Application No: A/142/17/PL

Recommendation Report for Planning Permission

LOCATION: Land at Barn Farm
Dappers Lane
Angmering
BN16 4EN

PROPOSAL: Change of use of land from storage (B8 Storage or Distribution) to a car sales yard (Sui Generis).

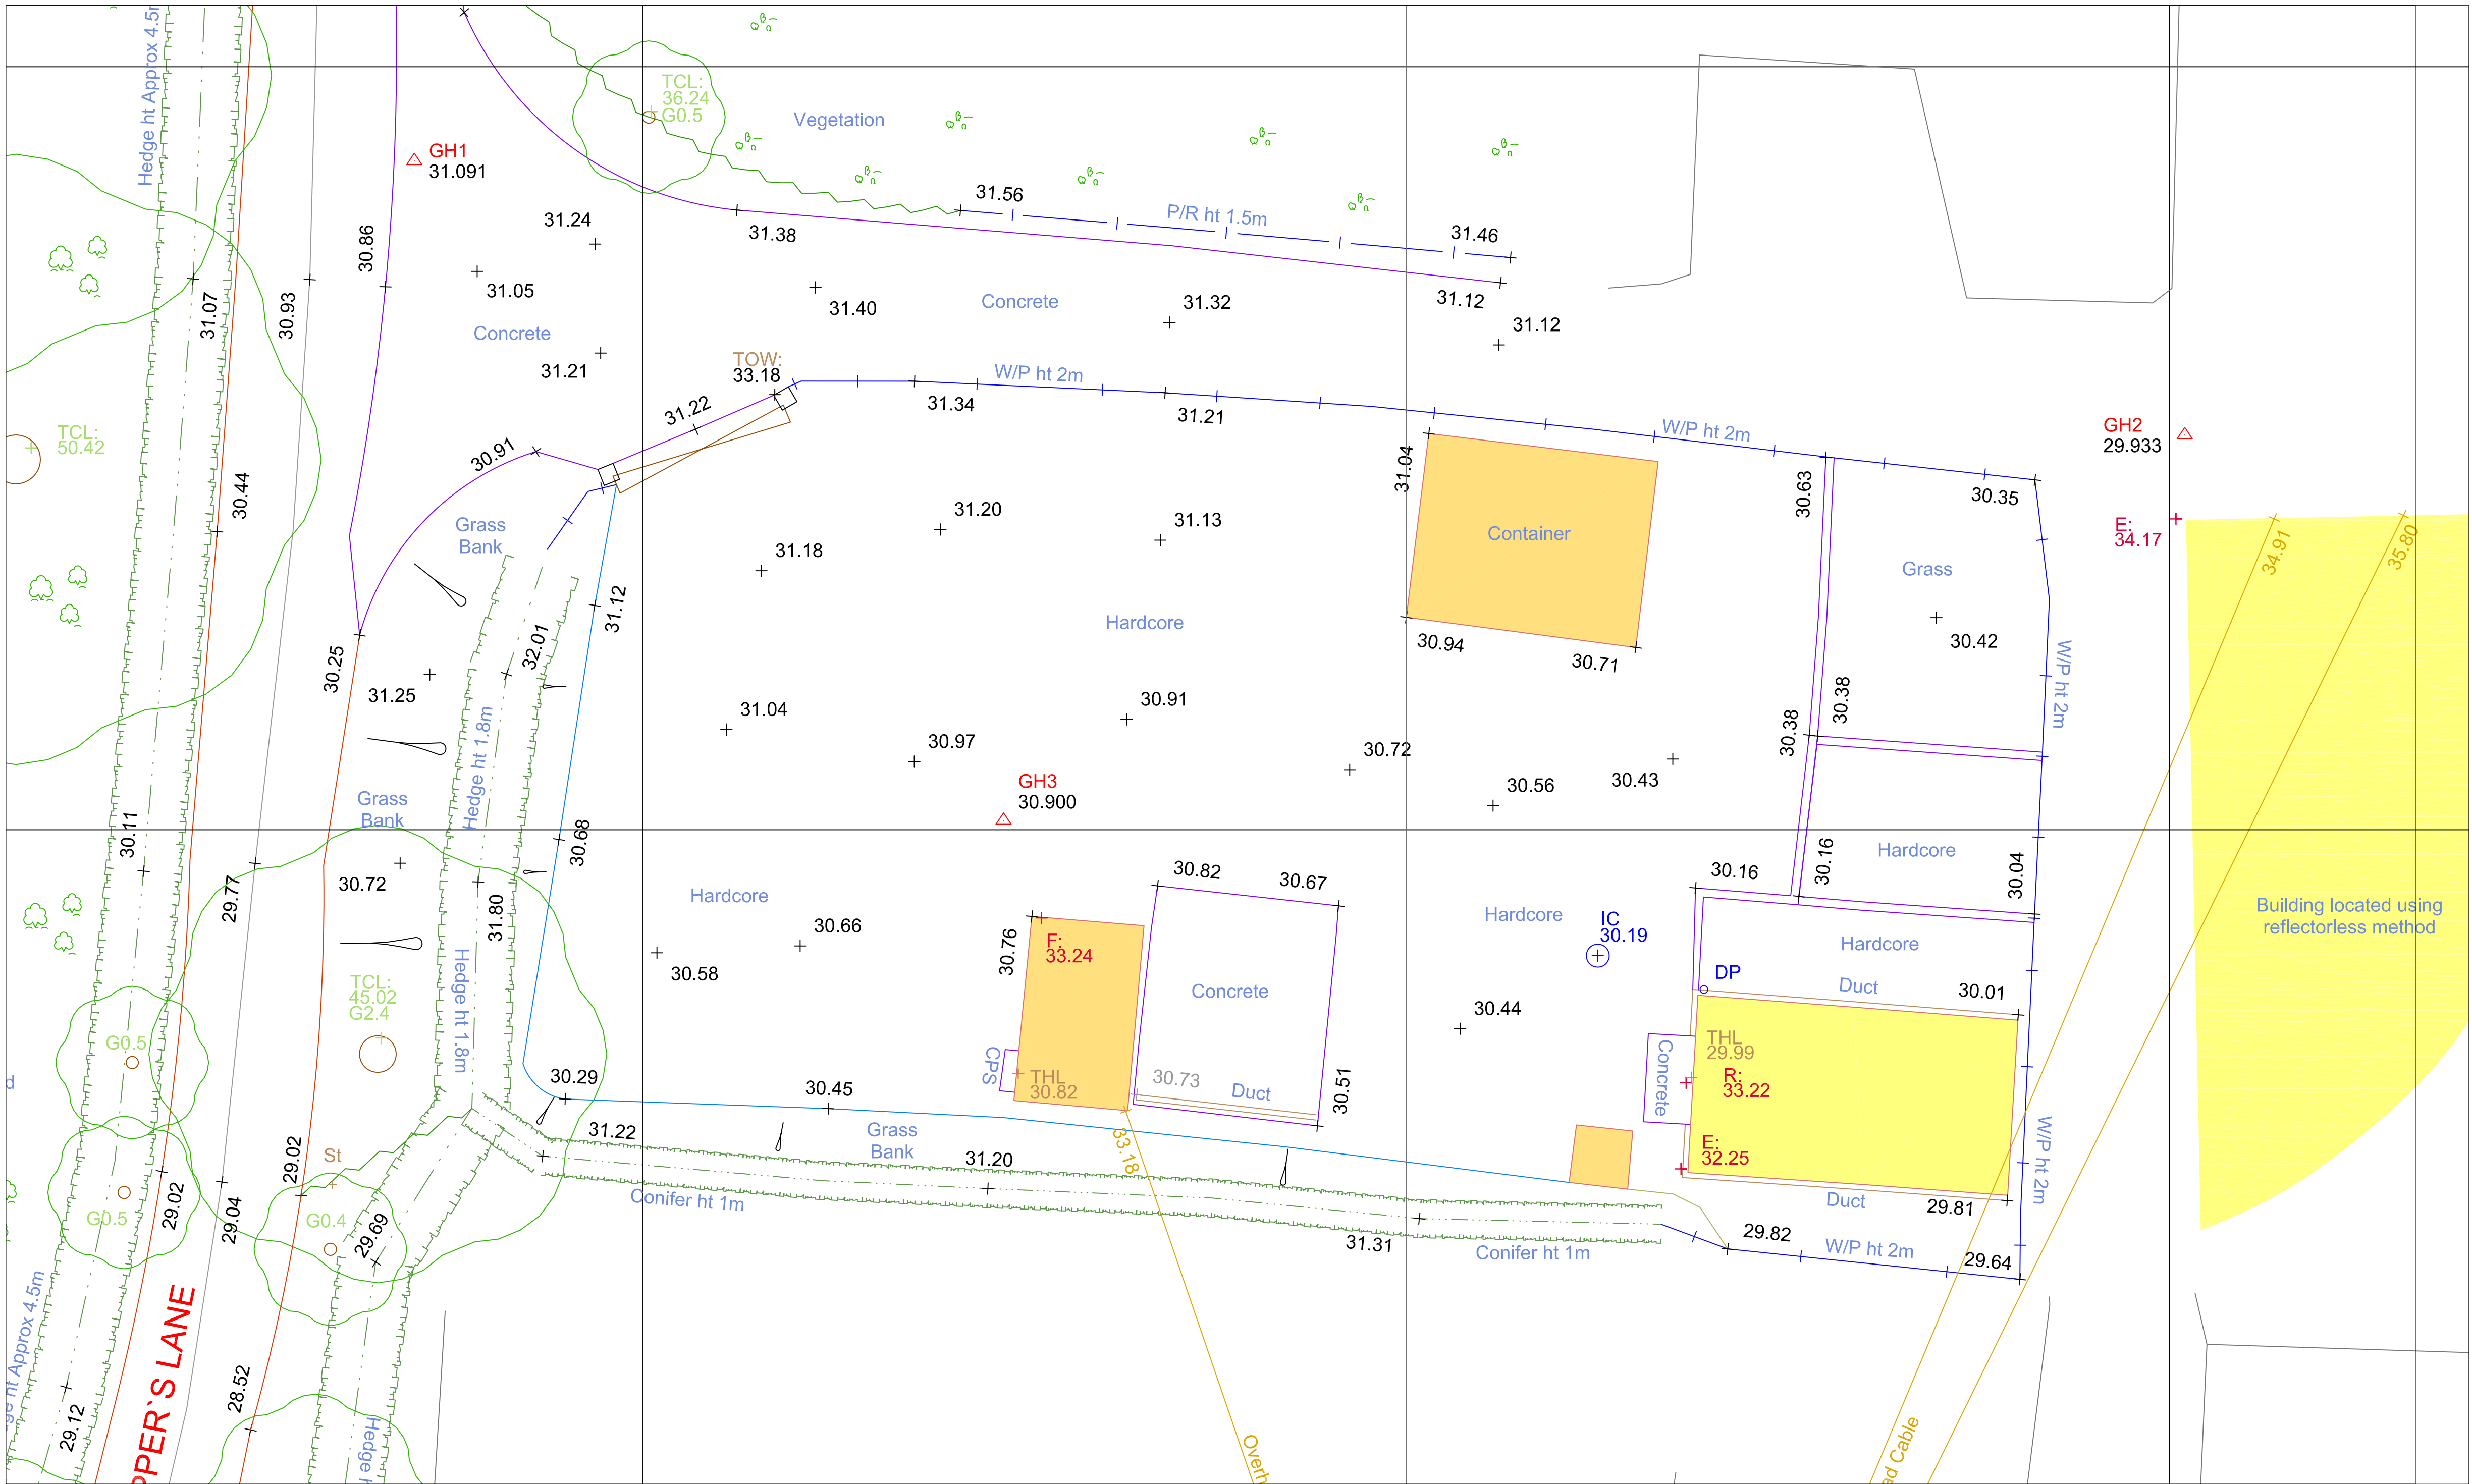
- No Tree Survey data or Arboricultural Impact Assessment has been submitted by the applicant.
- Following significant loss of established roadside trees at the site since 2014, there remains only one tree of value that is implicated by the proposed site development; a mature roadside oak (T1). It would easily qualify as a Category B tree using the BS5837 method when considering suitability for retention. This tree is showing signs of physiological distress, most likely attributable to the change in soil level imposed by the recent and historic formation of roadside bunds, introduction of new surface materials and driveway construction at the property adjoining to the south. All of this disturbance has occurred within the Root Protection Area (RPA) of T1. The tree remains viable for long-term retention and has a good chance of full recovery if further interference above and below ground is avoided.

- There are no plans to locate any materials or semi-permanent structures within the RPA of T1, but there remains a risk of the latter occurring.
- I recommend APPROVAL for this application in its current form, subject to the following conditions being applied and the making of a Tree Preservation Order.

Having looked at their plans, it is noted that the application will not make any improvements to the current surface water runoff arrangements on site, whereby surface water run-off is likely to be shed onto Dappers Lane in certain storm events, which in turn causes issues in Angmering village.

- 10 No buildings or containers shall be placed within 10 metres of the tree at the southern end of the western boundary and no changes of existing ground levels as shown on approved plan TDA.2315.02 shall take place within the same radius of the tree within the application site and adjacent bank.
